**M54 to M6 Link Road
TR010054**

**8.8 LIU(K) Statement of Common
Ground with Nurton Developments
(Hilton) Limited**

**M54 to M6 Link Road
Development Consent Order 202[]**

DESIGN SPEED N/A  
(WORK No. 28)  
ACCOMMODATION OVERBRIDGE  
LONGITUDINAL SECTION CH. 0m - CH. 510m  
SCALE @ A1 - HORIZ 1:1250 VERT 1:250

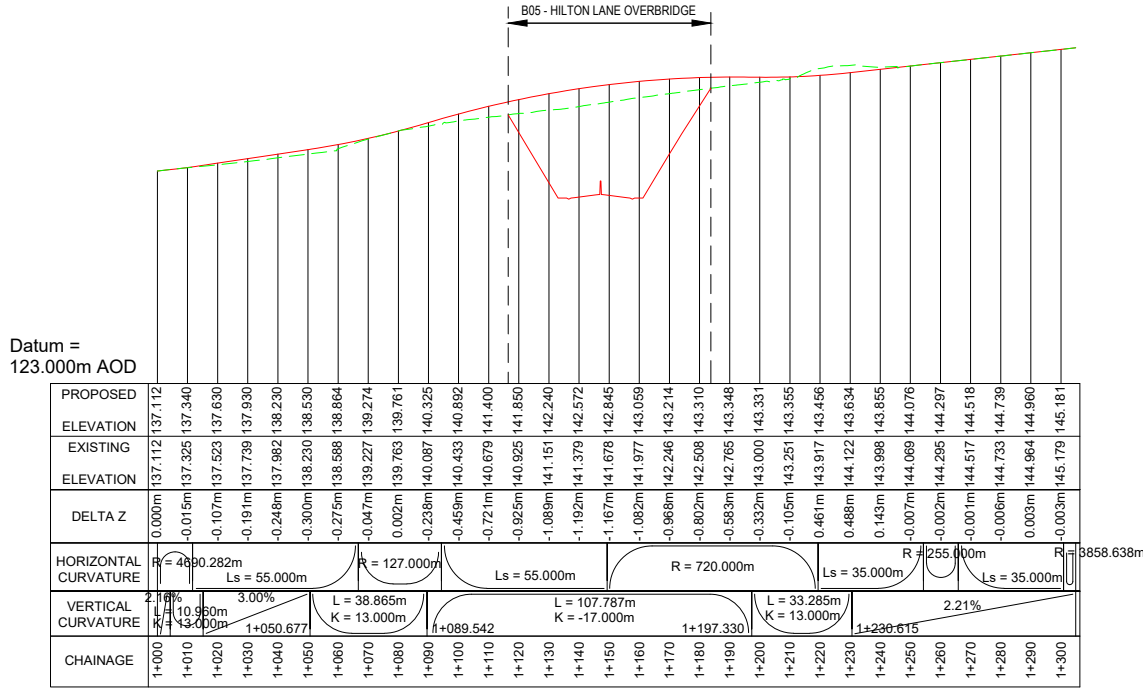
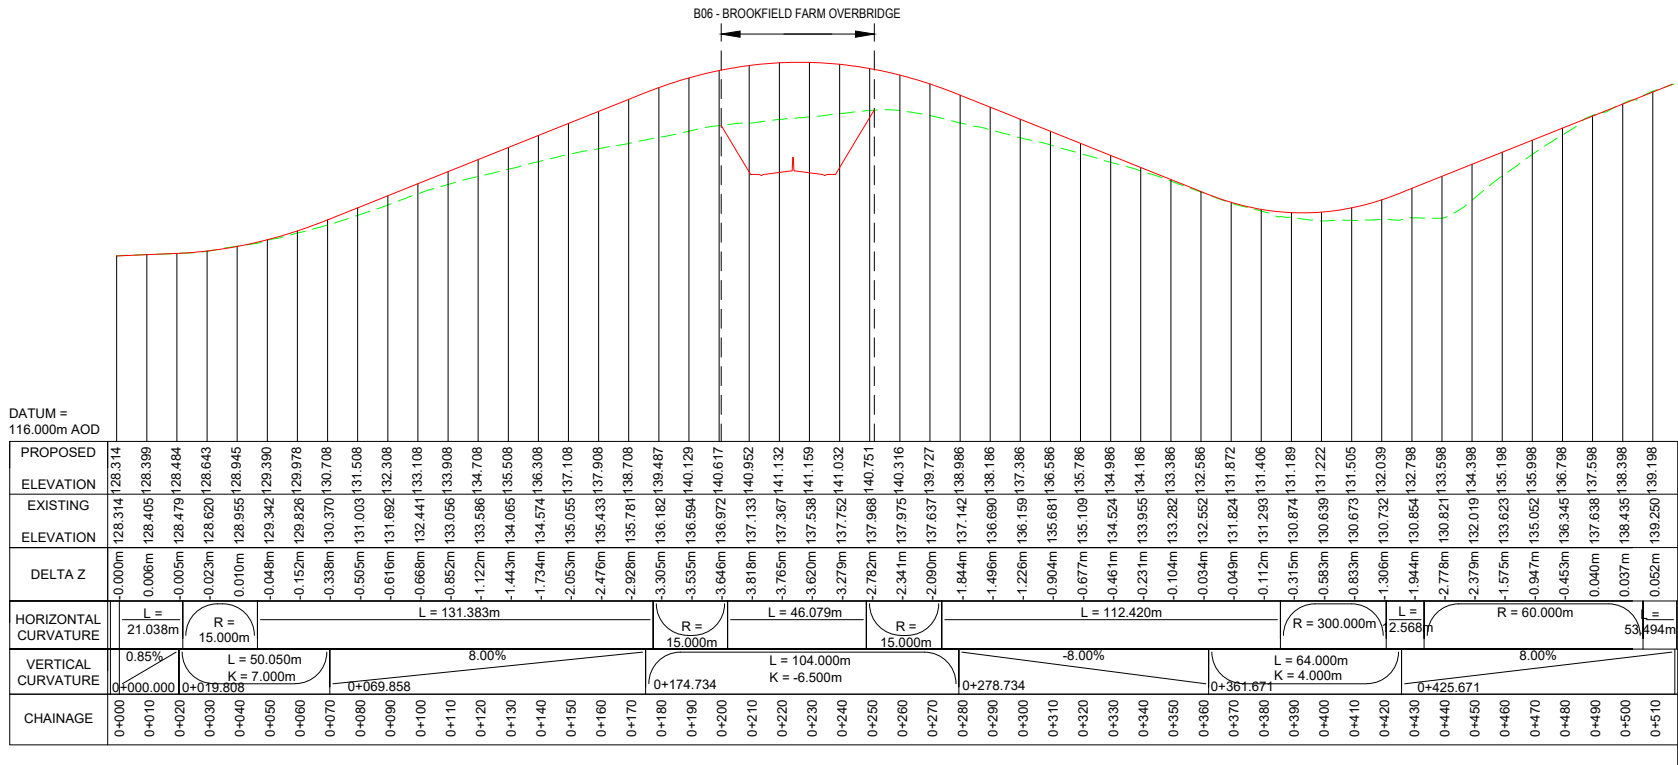
Document	Subject	Nurton Developments Limited Comment	Highways England Response	Status	Agreement likely ¹
		We are aware of no other potential new freestanding strategic employment sites that are being promoted by other parties.			
Relevant Rep. 038	Bridge design and location at Hilton Land and Brookfield Farm	Nurton requested information from HE on the alternative solutions considered on the bridge design. Highways England responded as presented here. Nurton remain of the view that insufficient information has been provided on bridge alternatives.	Highways England is of the view that bridge alternatives have been considered sufficiently and communicated to Nurton, particularly given that the site does not have planning permission and is not allocated. The response below is that provided to Nurton. The bridges in question are the proposed bridge to be installed to enable Hilton Lane to cross the mainline and the accommodation bridge further north at Brookfield Farm to access their land on the other side of the new link road for existing purposes. The alternatives considered have been discussed with Nurton prior to the submission of the Application, with further correspondence prior to Nurton submitting its Relevant Representation. This includes discussions at the meeting on 2 December 2019 (see Appendix C) and a letter from Highways England to Nurton on 20 February 2020 (see Appendix D). Several suggestions for the bridge have been put forward by Nurton, each of which are explored further below.	Not Agreed	Not Agreed

Document	Subject	Nurton Developments Limited Comment	Highways England Response	Status	Agreement likely ¹
			<p>1/ HE understands that Nurton would like the proposed accommodation bridge to be widened to accommodate traffic that may access employment development on adjacent land, should planning permission be granted for it in the future.</p> <p>A meeting was held between Highways England and Nurton on 2 December 2019 where this matter was discussed (please see minutes in Appendix C). At this meeting Nurton explained that to facilitate the development, the bridge should be 11.3 m wide (7.3 m road, 3 m footpath and 1 m verge) as opposed to the proposed 6 m wide bridge (4.5 m road and 0.75 m verge on either side).</p> <p>As HE explained at the meeting on 2 December, the proposed increase in bridge width would increase costs and environmental impacts and therefore cannot be justified. The bridge design proposed to be constructed is typical of accommodation bridges to enable farm machinery to access adjacent plots of land. Following discussion with the landowners, Nigel and Paul Simkin, it was confirmed that the largest road legal combine harvester requires access across this structure (4m width). Therefore, the paved width across the bridge was increased from 4m to 4.5m.</p>

Document	Subject	Nurton Developments Limited Comment	Highways England Response	Status	Agreement likely ¹
			<p>2/ HE has also considered Nurton's request to combine the bridge at Hilton Lane and the accommodation bridge, relocating it to a location between the two. Moving the bridge further from Hilton Lane would require construction of additional carriageway from Hilton Lane to the new bridge, resulting in significant additional costs and environmental impacts. It would require the acquisition of additional land that would not be justified in this instance. This was explained at the meeting on 2 December 2019 and in the letter from HE to Nurton Developments on 20 February 2020.</p> <p>At the meeting on 2 December 2019, HE also explained that three alternatives had been considered for the location of the accommodation bridge:</p> <ul style="list-style-type: none"> (i) a main crossing over Hilton Lane; (ii) a crossing midway between Hilton Lane and proposed location; (iii) the proposed location. <p>It was considered that the proposed location was the best balance between the diversion length of the bridleway (already at 12% of its total length against a guideline maximum of 10%) and allowing an appropriate gradient</p>

Document	Subject	Nurton Developments Limited Comment	Highways England Response	Status	Agreement likely ¹
			(which will now be 8%) for the ramp up to the crossing. HE considers that sufficient information has been provided on the alternatives considered for this bridge and that reasonable alternatives have been considered.		
Relevant Rep. 038	Lack of information regarding alternatives on location and design of pond areas	<p>Following the response provided in the column to the right, Nurton remains of the view that insufficient information has been provided on pond alternatives.</p> <p>There is also a lack of information regarding alternatives considered in respect of the location and design of the pond areas. Having reviewed the information available, at present these conform to standard design, rather than being bespoke to a Scheme of this scale. In the absence of a consideration of alternative designs, it is difficult to understand how the adverse impacts of the Scheme have been mitigated by HE.</p>	<p>Highways England is of the view that sufficient information has been provided on pond alternatives.</p> <p>There are four ponds within the area Nurton has an interest over; two ponds to be created for attenuation purposes and two for ecological purposes. These are necessary for the delivery of the Scheme.</p> <p>The attenuation ponds on land being promoted by Nurton are located to the south west of Brookfield Farm and the south west of M6 Junction 11. These ponds are located at the low points adjacent to ditches to allow the outfall to drain to the existing ditches. The ponds are in the optimal location, with the location of the pond being dictated by topography and the location of the ditches. The shape of the attenuation ponds has been designed to minimise land take. The ponds have been designed to drain the Scheme, and their design is bespoke to it.</p> <p>The two ponds proposed for ecological purposes are located to the east of the link</p>	Not Agreed	Not Agreed
